Application Comment Report

Application No. LUPL-25-0008

Record Type : Land Use Plan

Document: 241010_BLR Village C Land Use Plan.pdf

ISSUE RECORD

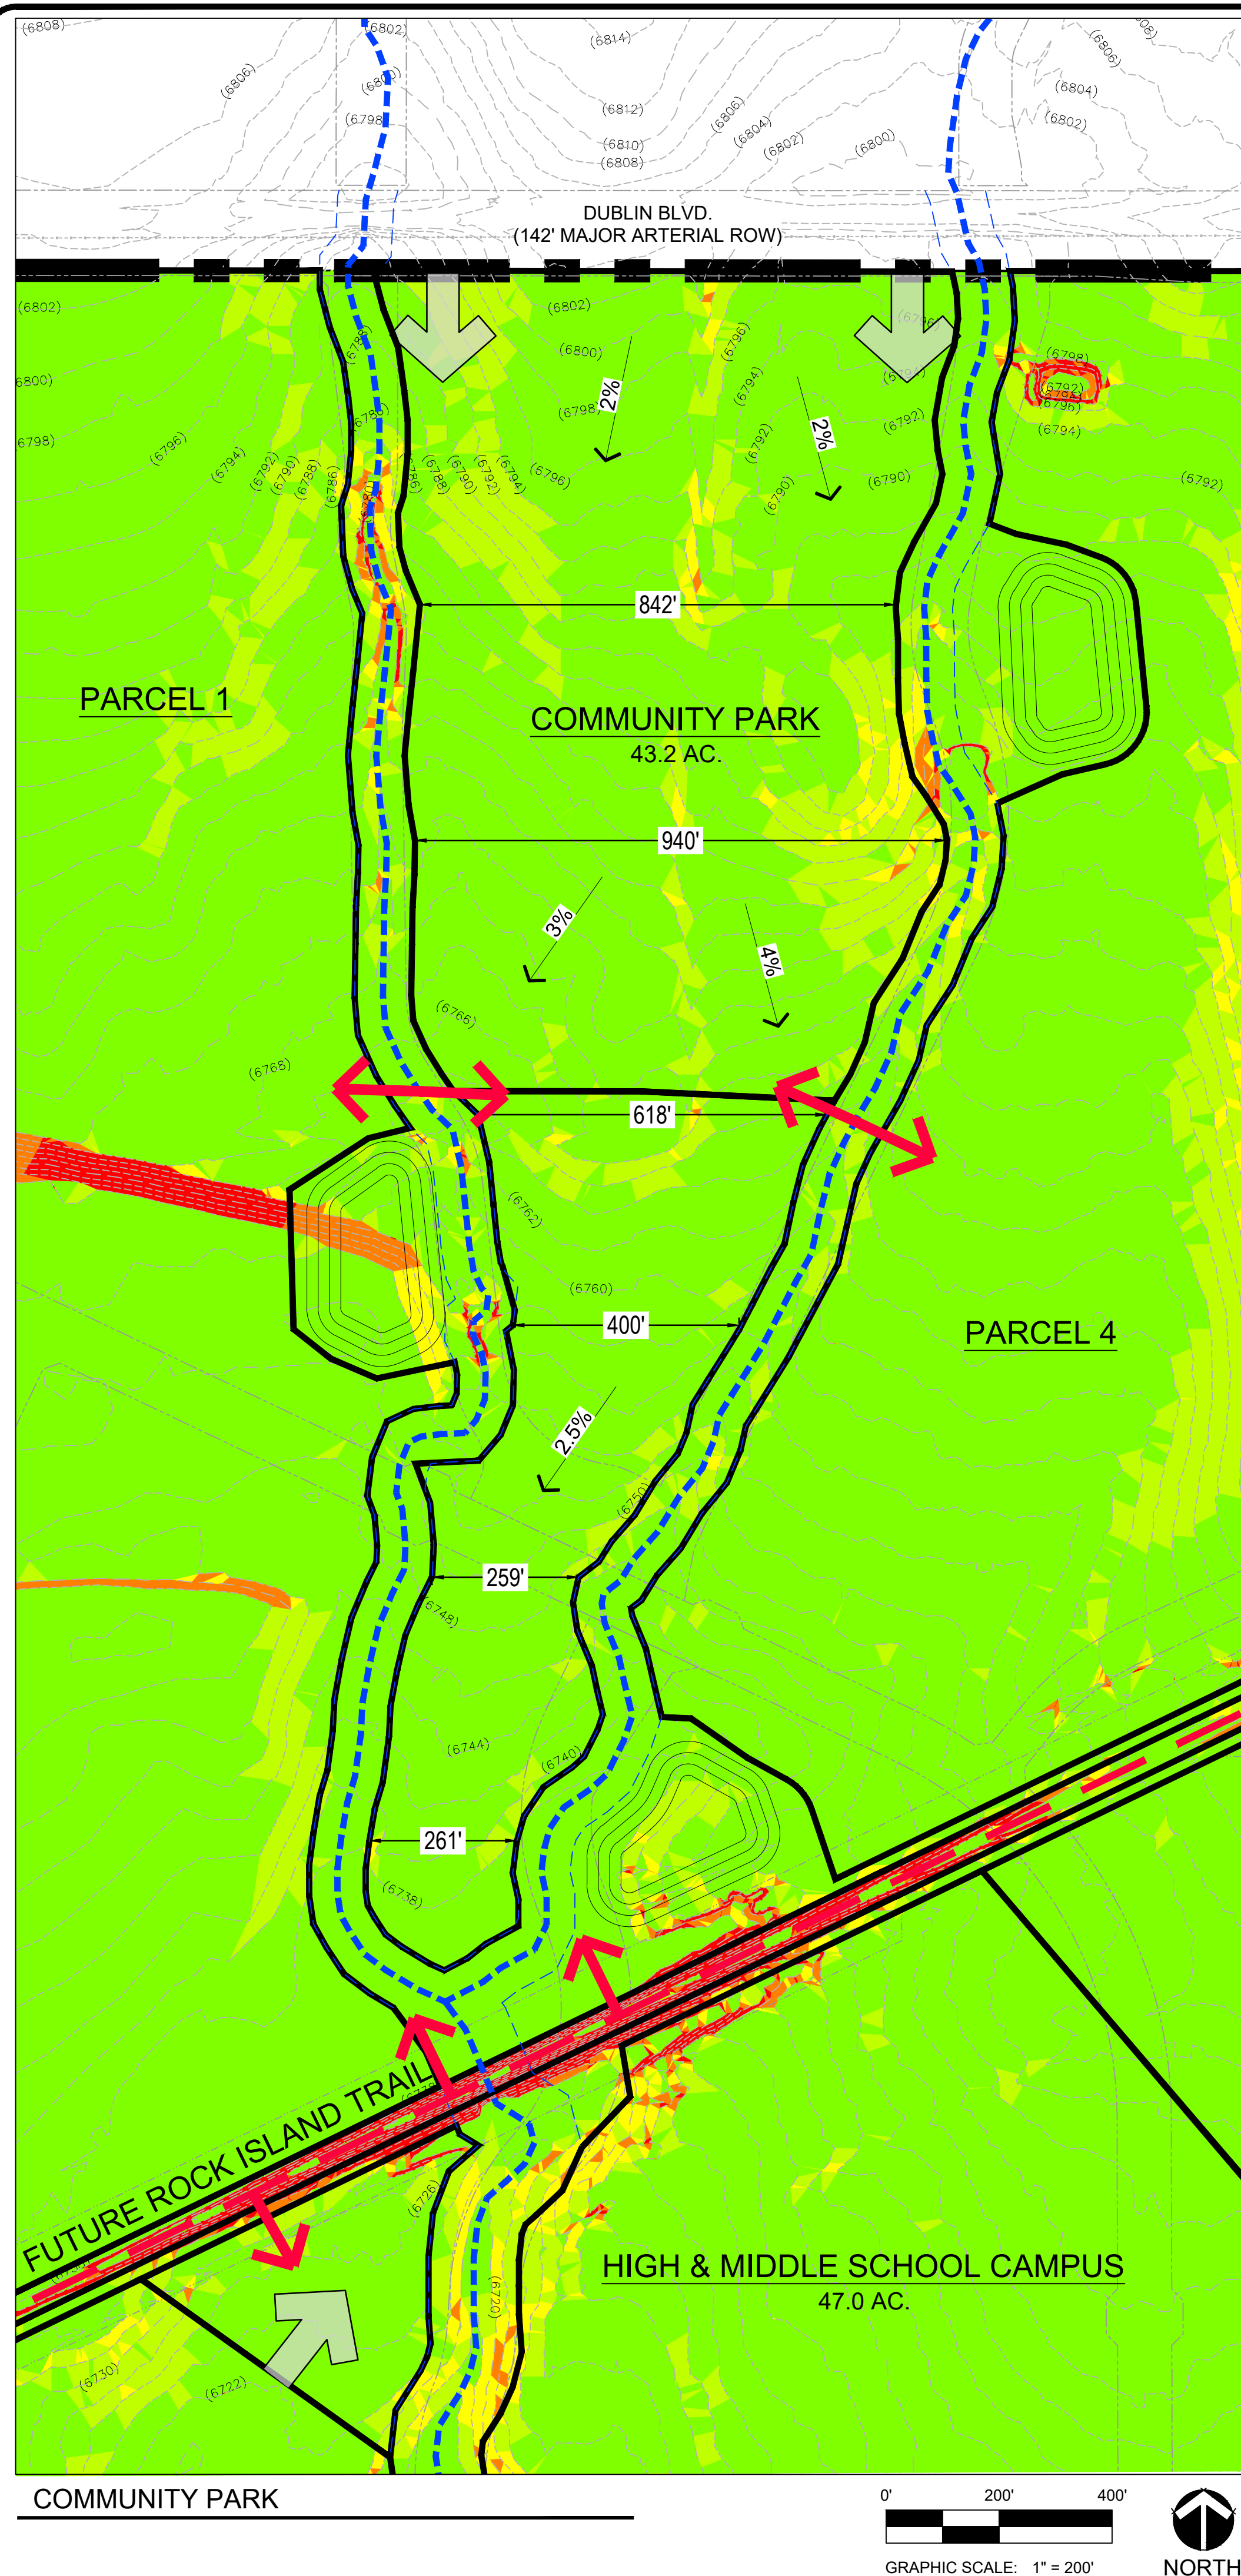
| Comment ID | Page Reference | Annotation Type | Reviewer : Department | Status | Review Comments | Applicant Response Comments |
|------------|----------------|-----------------|--|--------|---|--|
| 2 | 2 | Note | Zaker Alazzeh : City Eng - Traffic Engineering | Open | The developer shall dedicate the appropriate right-of-way along the northern property line of Parcel 6, located on Dublin Boulevard. This dedication must align with the western property line right-of-way existing roadway and meet the city's standards. Please coordinate with city traffic engineering on the ROW dedication. | <p>Guest - 10-28-2025 15:04:11</p> <p>Dublin Blvd north of Parcel 7 now has a 70' ROW per the 9/8/2025 meeting with Oakwood, LAI, Classic Consulting, City Traffic, and El Paso County Engineer.</p> |

| Comment ID | Page Reference | Annotation Type | Reviewer : Department | Status | Review Comments | Applicant Response Comments |
|------------|----------------|-----------------|----------------------------|--------|---|---|
| 70 | 2 | Note | Caroline Miller : Planning | Open | Please revise cells to match above unit counts. | |

| Comment ID | Page Reference | Annotation Type | Reviewer : Department | Status | Review Comments | Applicant Response Comments |
|------------|----------------|-----------------|----------------------------|--------|---|--|
| 71 | 2 | Note | Caroline Miller : Planning | Open | <p>With the change to Community Park acreage, staff would like to understand the road connections for the Community Park site and the residential area to the south. What is the thought for the road design? Will a connector road be built through the Community Park site, connecting to the residential area, thereby limiting the Community Park acreage to a full-access public road?</p> <p>In addition, will there be any other road access points off of Dublin, or just the Community Park area? Feel free to reach out to the reviewer to discuss in a meeting if preferred.</p> | <p>Guest - 10-28-2025 15:17:40</p> <p>Noted and a meeting with parks will be scheduled at the appropriate time.</p> |
| 75 | 2 | Callout | Tamara Baxter : Planning | Open | <p>What is the zoning for this area? Please call out.</p> | <p>Guest - 10-28-2025 15:22:33</p> <p>Zoning label added.</p> |
| 76 | 2 | Callout | Tamara Baxter : Planning | Open | <p>Please call out zoning for this area.</p> | <p>Guest - 10-28-2025 15:17:59</p> <p>Zoning label added.</p> |
| 77 | 2 | Callout | Tamara Baxter : Planning | Open | <p>Please call out zoning for this area. Should be reflective of the area shown in ZONE-25-0020</p> | <p>Guest - 10-28-2025 15:22:44</p> <p>Zoning label added.</p> |
| 78 | 2 | Callout | Tamara Baxter : Planning | Open | <p>Please call out zoning for this area. Should be reflective of ZONE-25-0021</p> | <p>Guest - 10-28-2025 15:21:01</p> <p>Zoning label added.</p> |

| Comment ID | Page Reference | Annotation Type | Reviewer : Department | Status | Review Comments | Applicant Response Comments |
|------------|----------------|-----------------|----------------------------|--------|---|---|
| 81 | 2 | Callout | Tamara Baxter : Planning | Open | As noted on the cover sheet, SF detached are conditional use in the MX-M zone district | Guest - 10-28-2025 15:23:14 SF detached is now identified as a conditional use in the table. |
| 83 | 2 | Note | Tamara Baxter : Planning | Open | Please clean up overlap so text is legible. | |
| 88 | 2 | Callout | Tamara Baxter : Planning | Open | Will future residential in this area be limited to the 3-156 du/ac, similar to R-Flex Med? | |
